Subject: planning applications

Re. No3/2012/0788: our council wish to object to this application:

Existing Site Plan
And Elevation

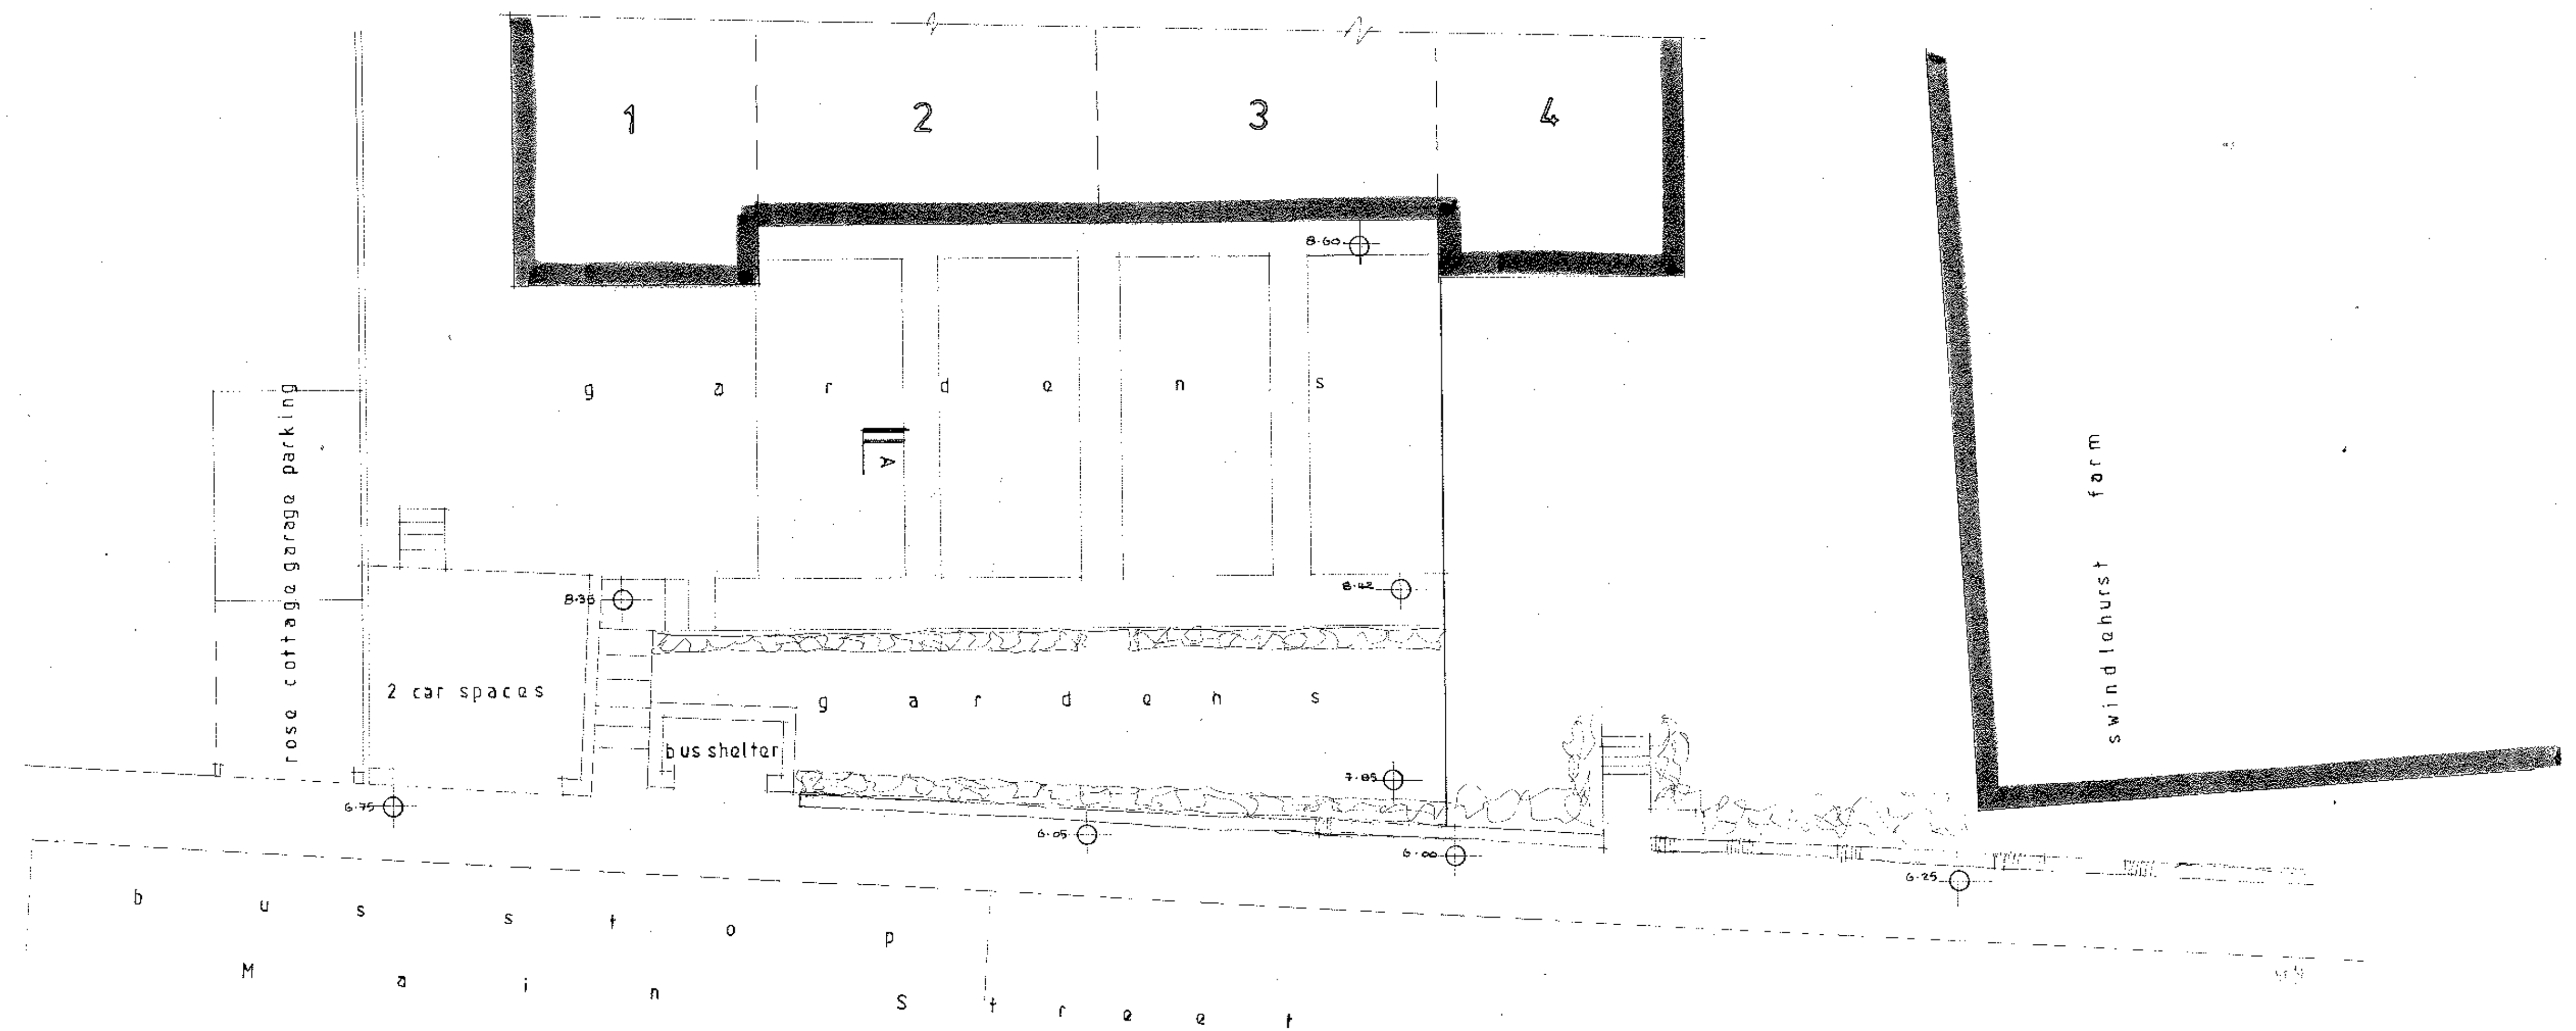
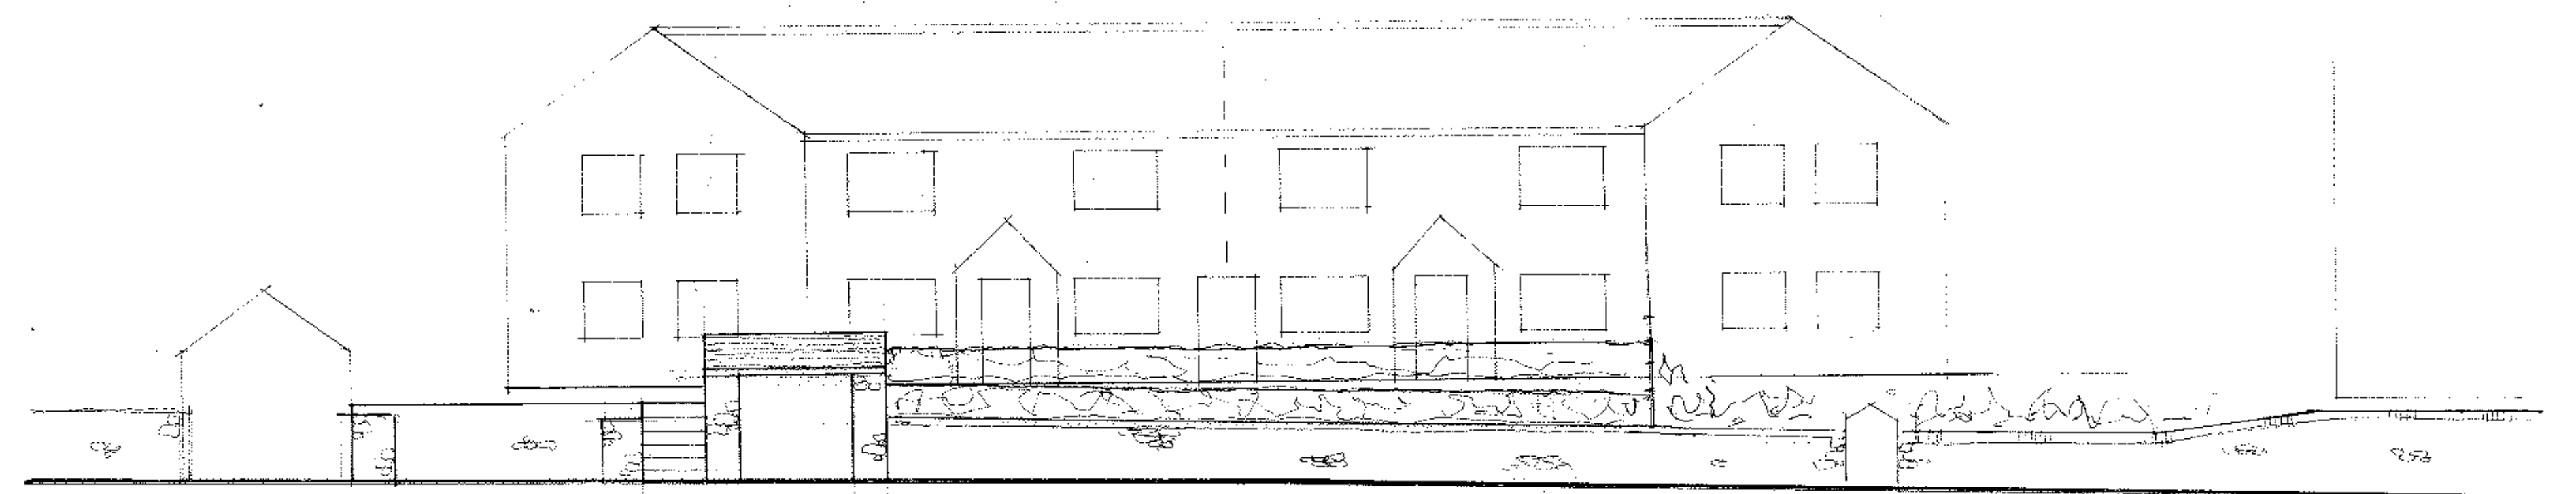
1. the council did not wish to lose their bus shelter.
2. The occupant of no 4 has a right of access but had not been consulted.
